Engineers Comments Regarding Surface Water Drainage

APPLICATION A/161/18/RES

2018
Site Address: Land to North of 68 Arundel Road Angmering BN16 4LL
Grid Reference: 506740 105247
Description of Works: Approval of reserved matters following outline consent A/31/18/OUT for 2 No dwellings.

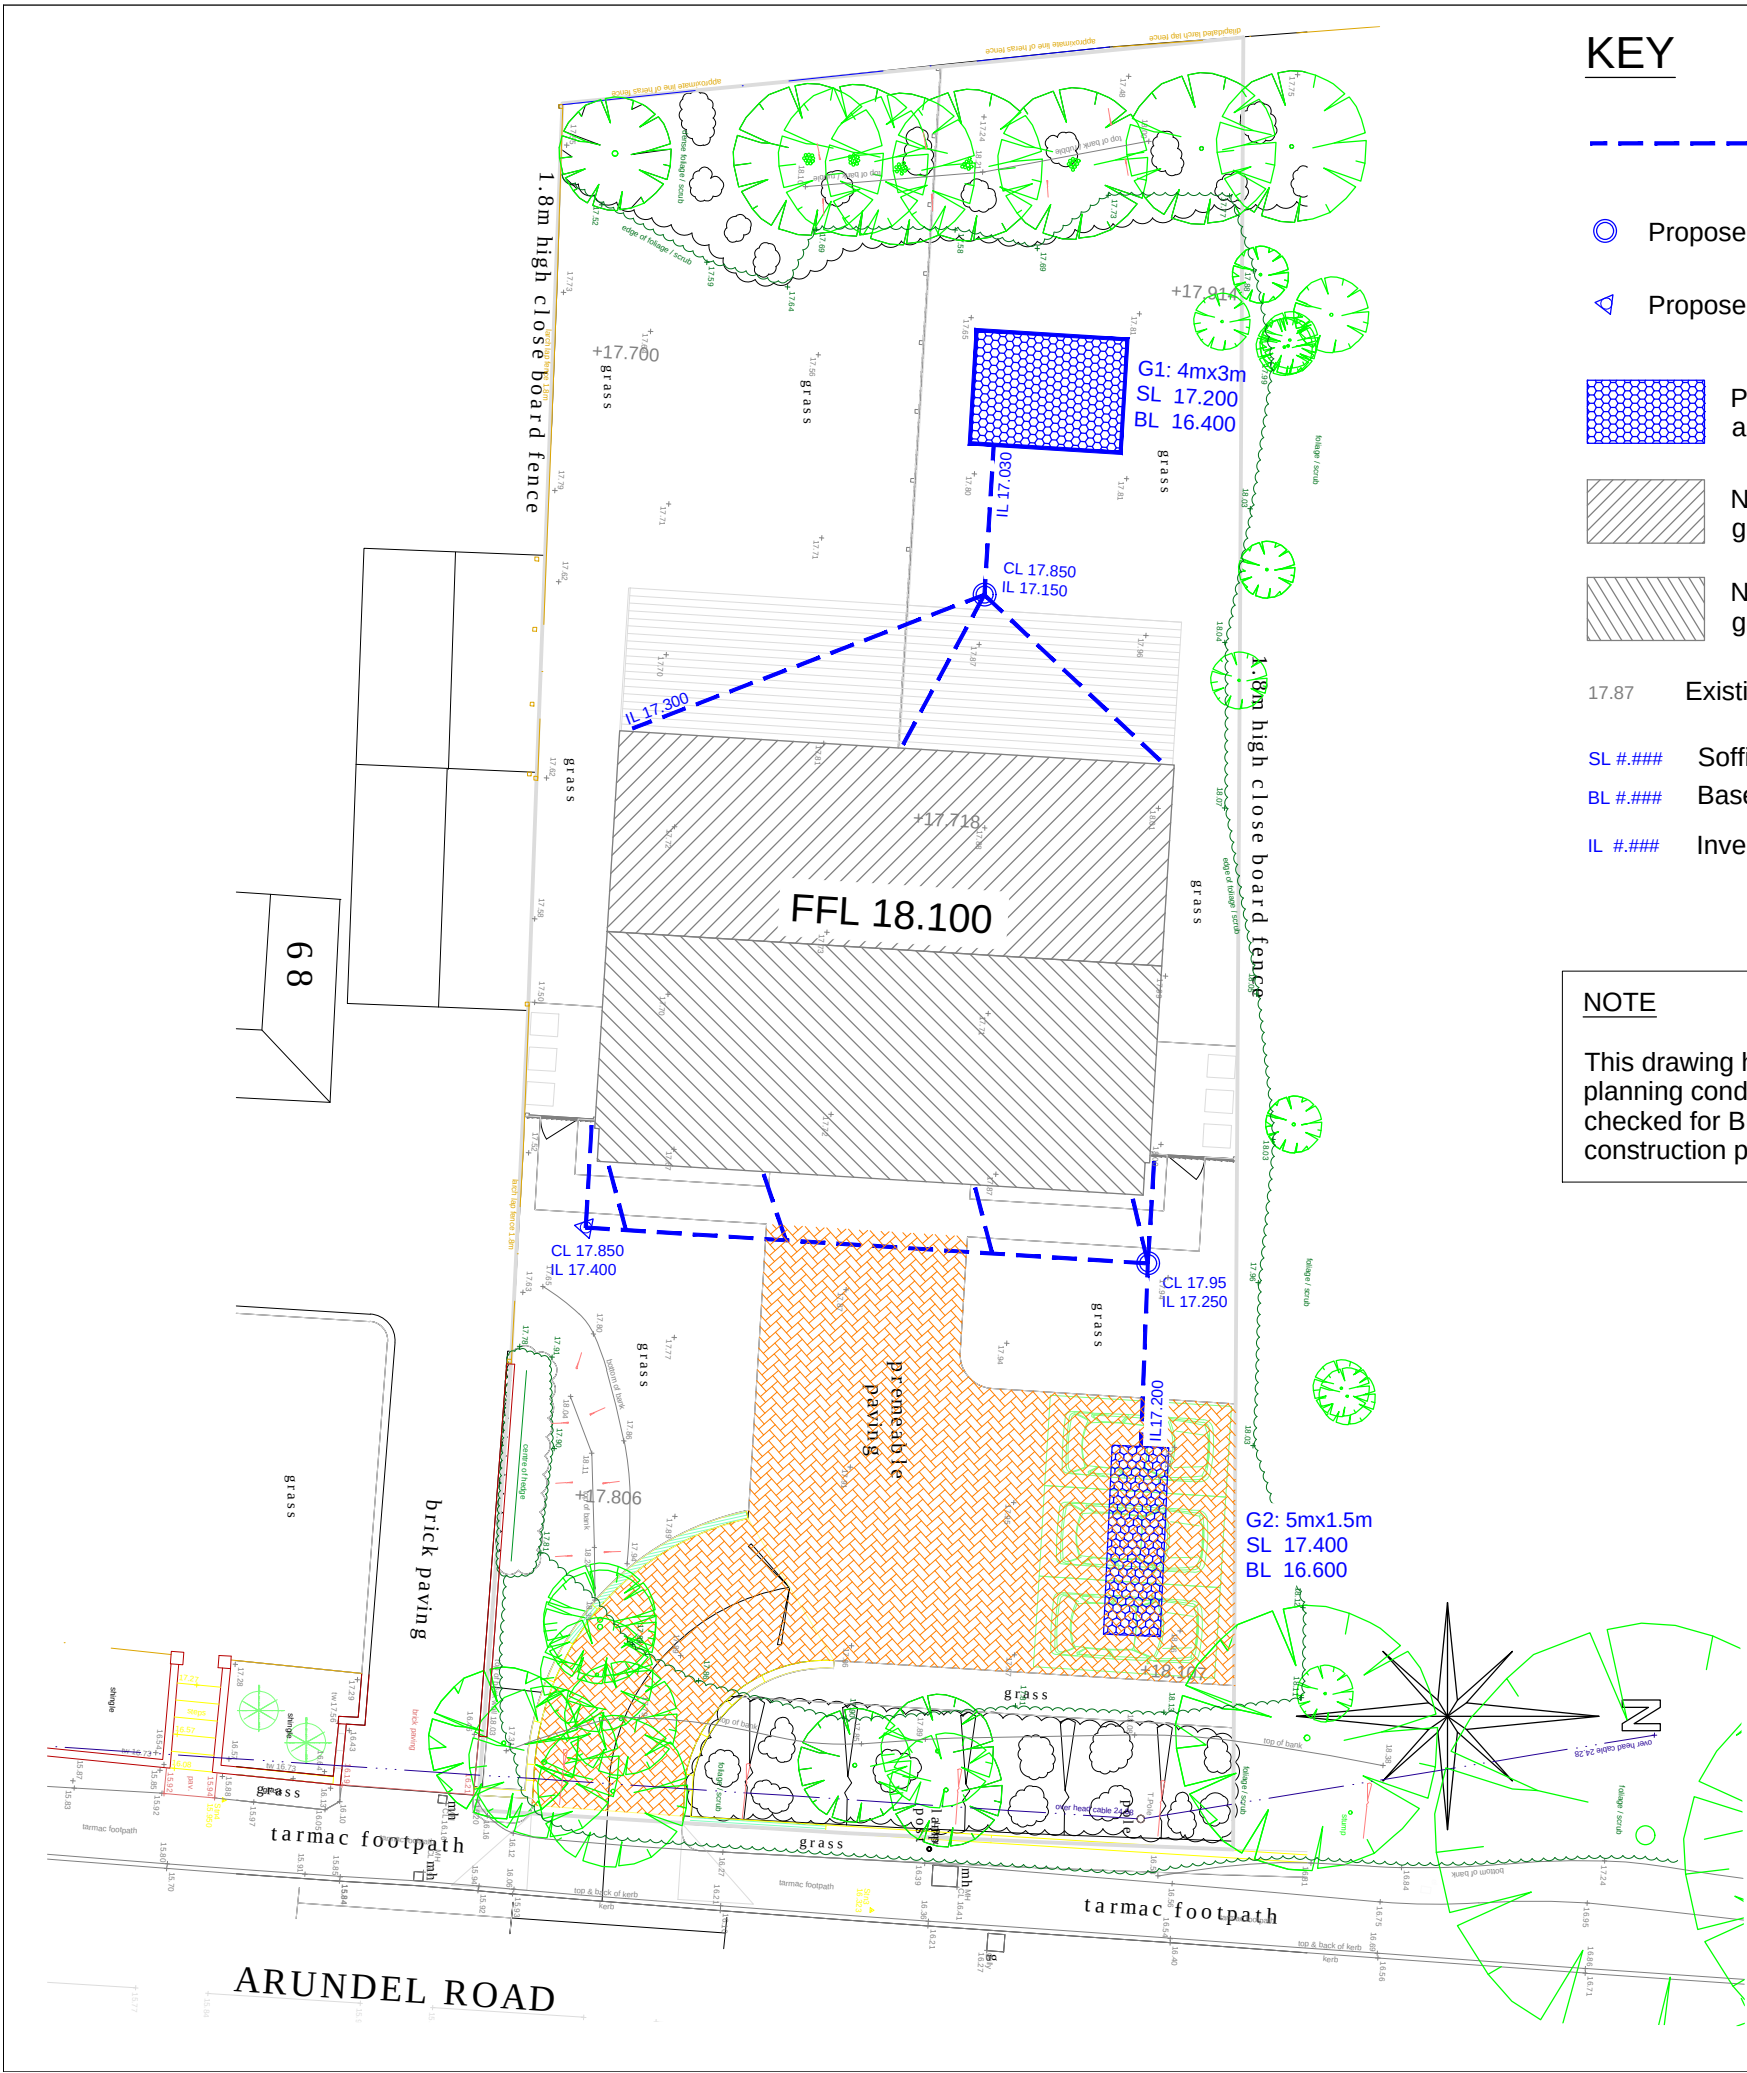
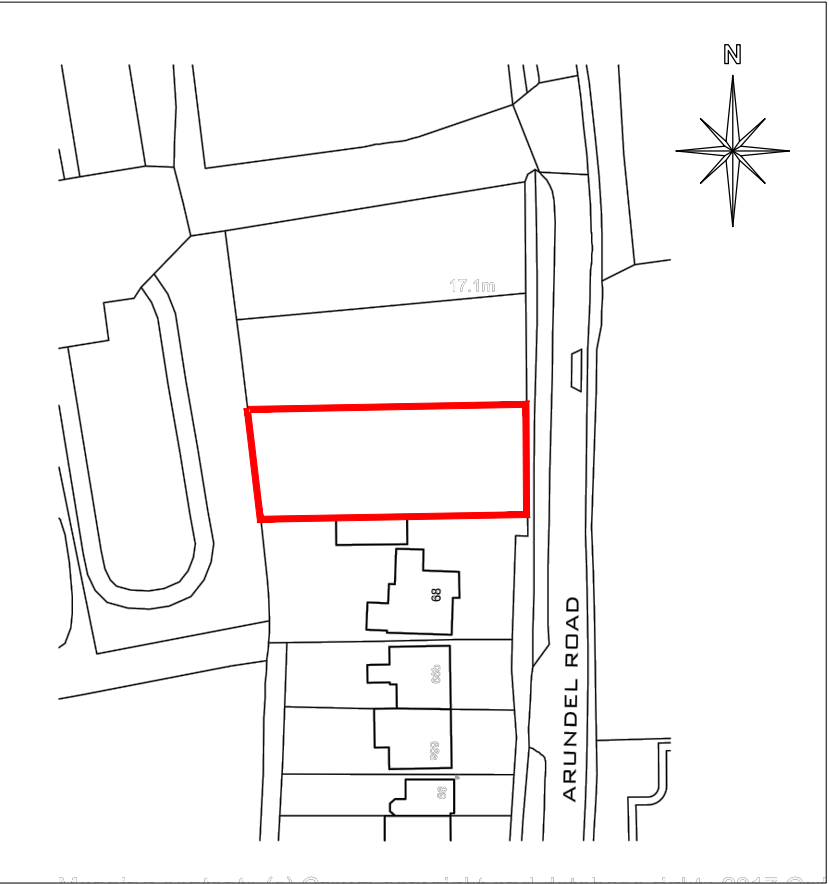
Should an application to discharge condition 5 be submitted the applicant will need to ensure the surface water drainage calculations and construction detail drawings are submitted with the drainage plan submitted.
